Park and Recreation Department

MEMORANDUM

RE: Rezoning Petition #2022-123

PID# 04545222, etc.

REZONING PLAN
RZ.01

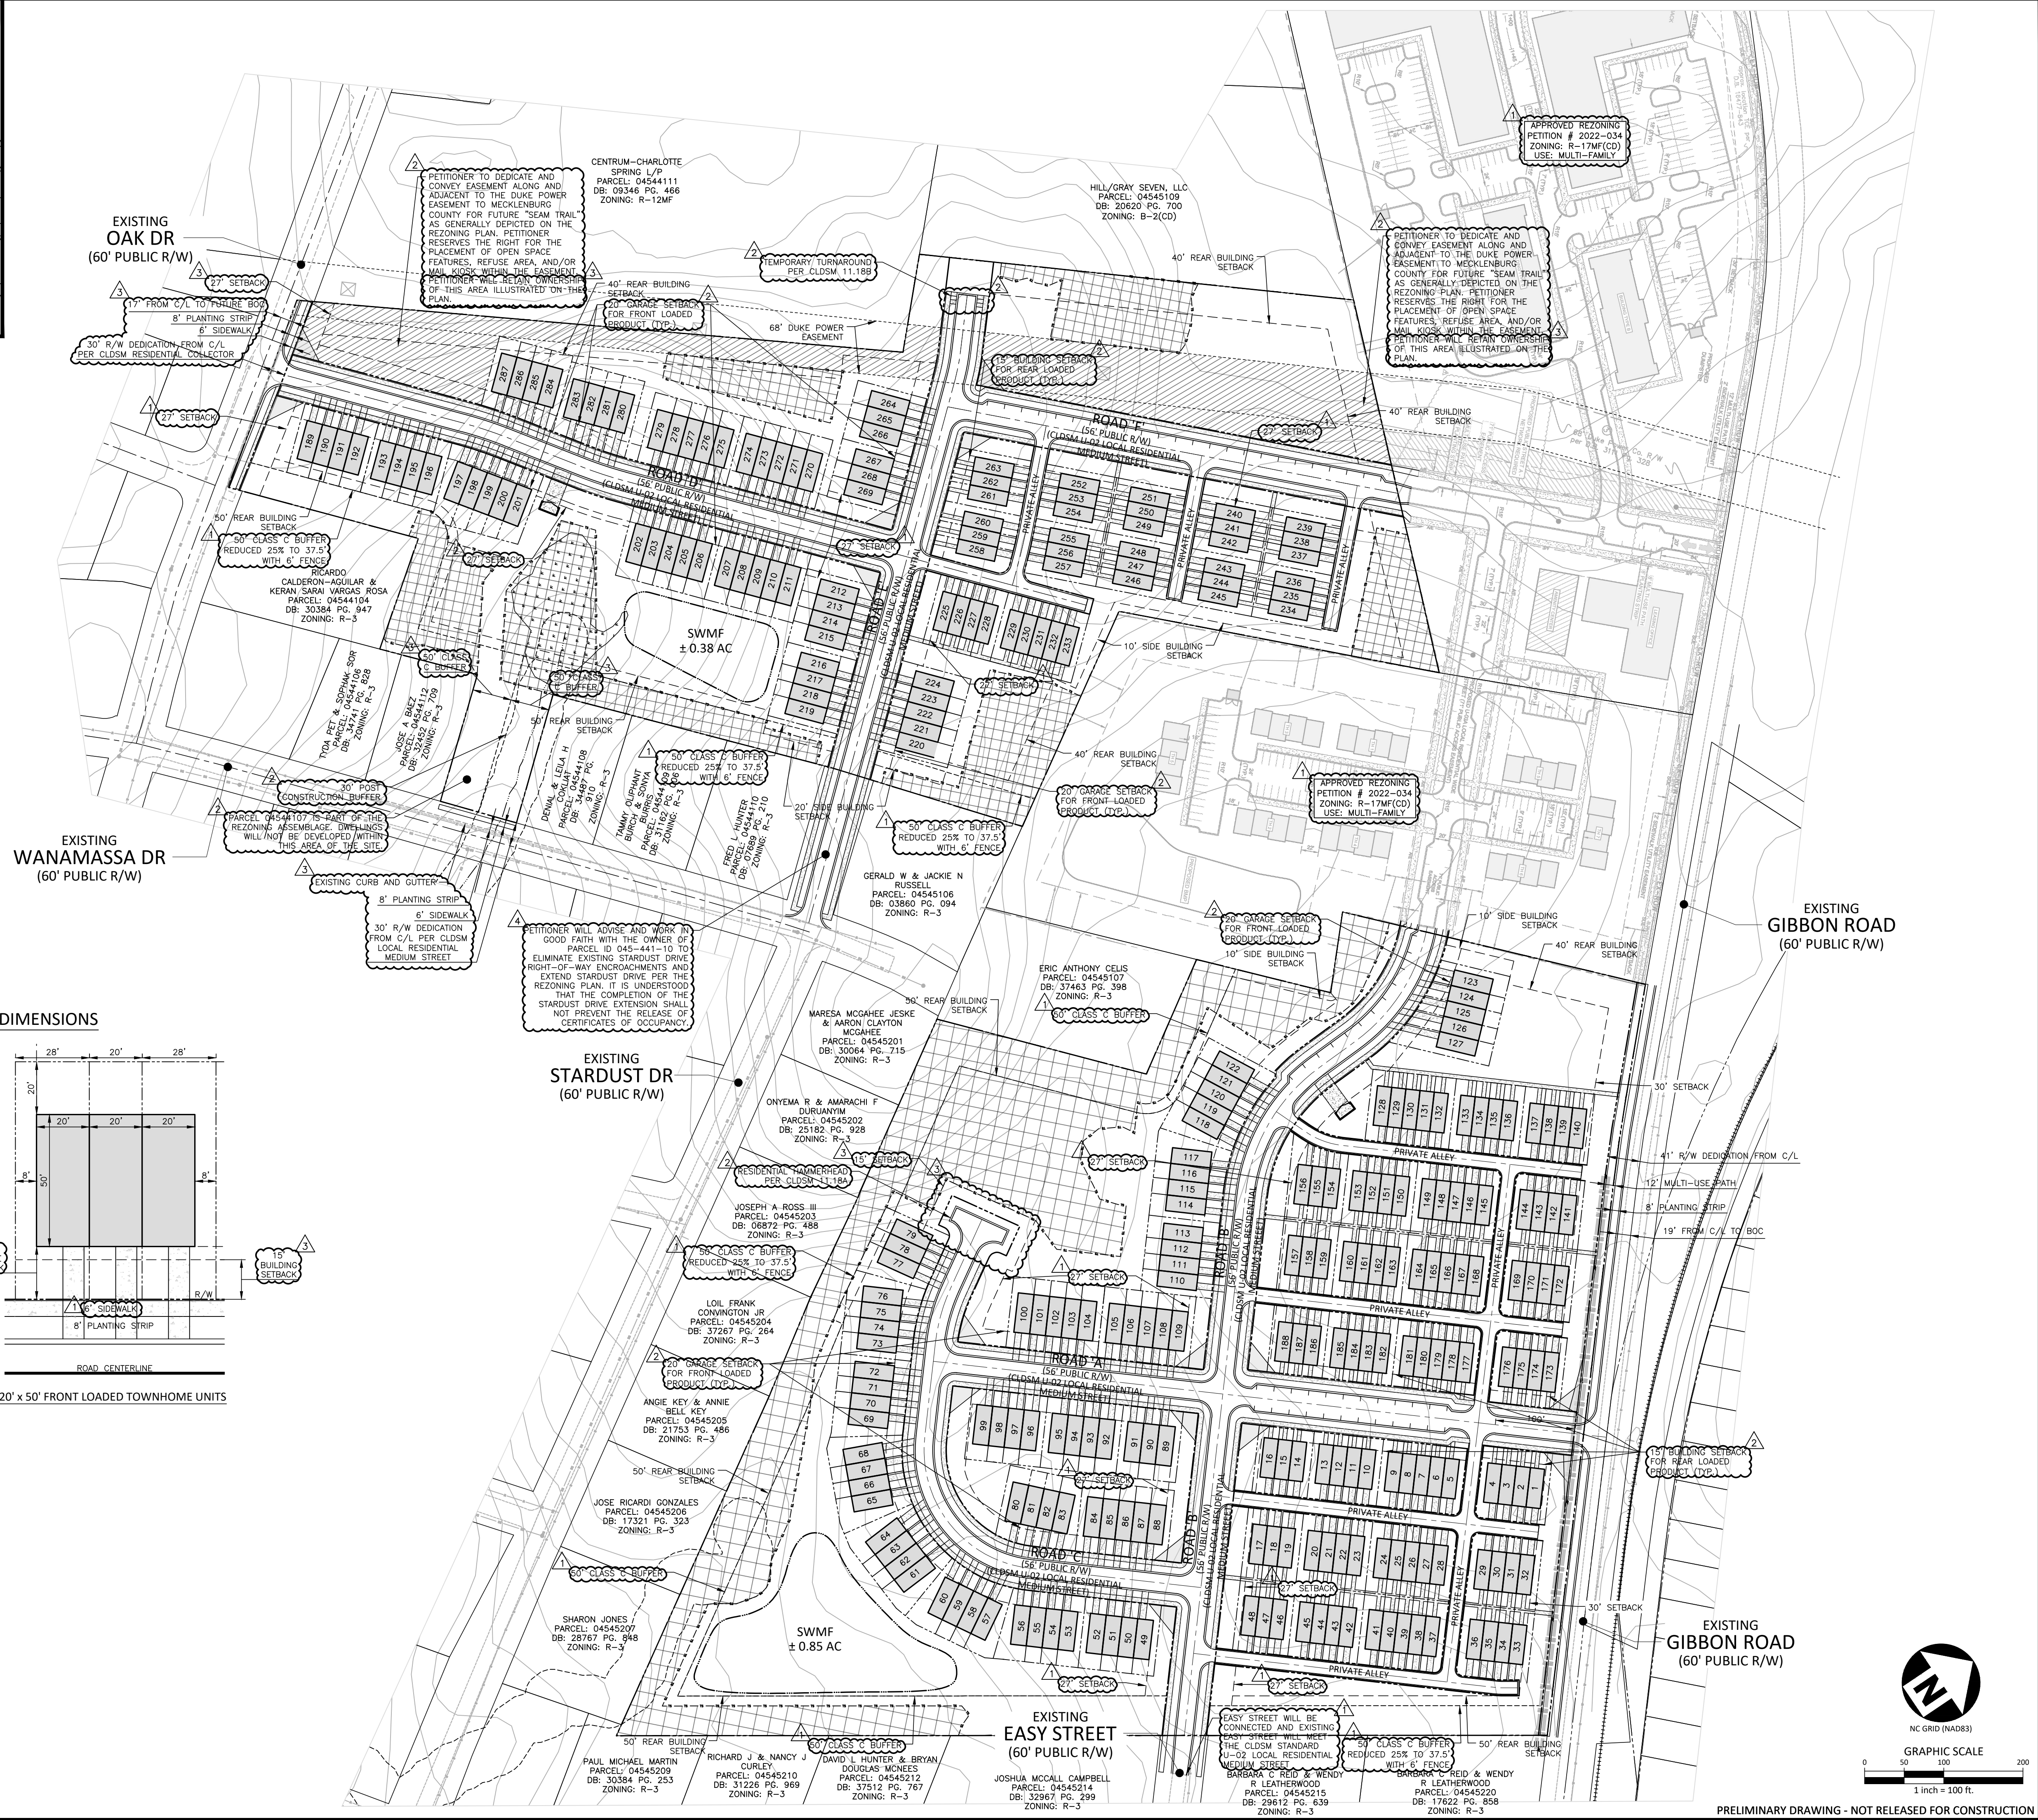
MCPR requests the petitioner dedicate and convey a minimum of 60' easement along and adjacent to the Duke Power Co. Easement to Mecklenburg County for the future "Seam Trail". See markups in Plan Room.
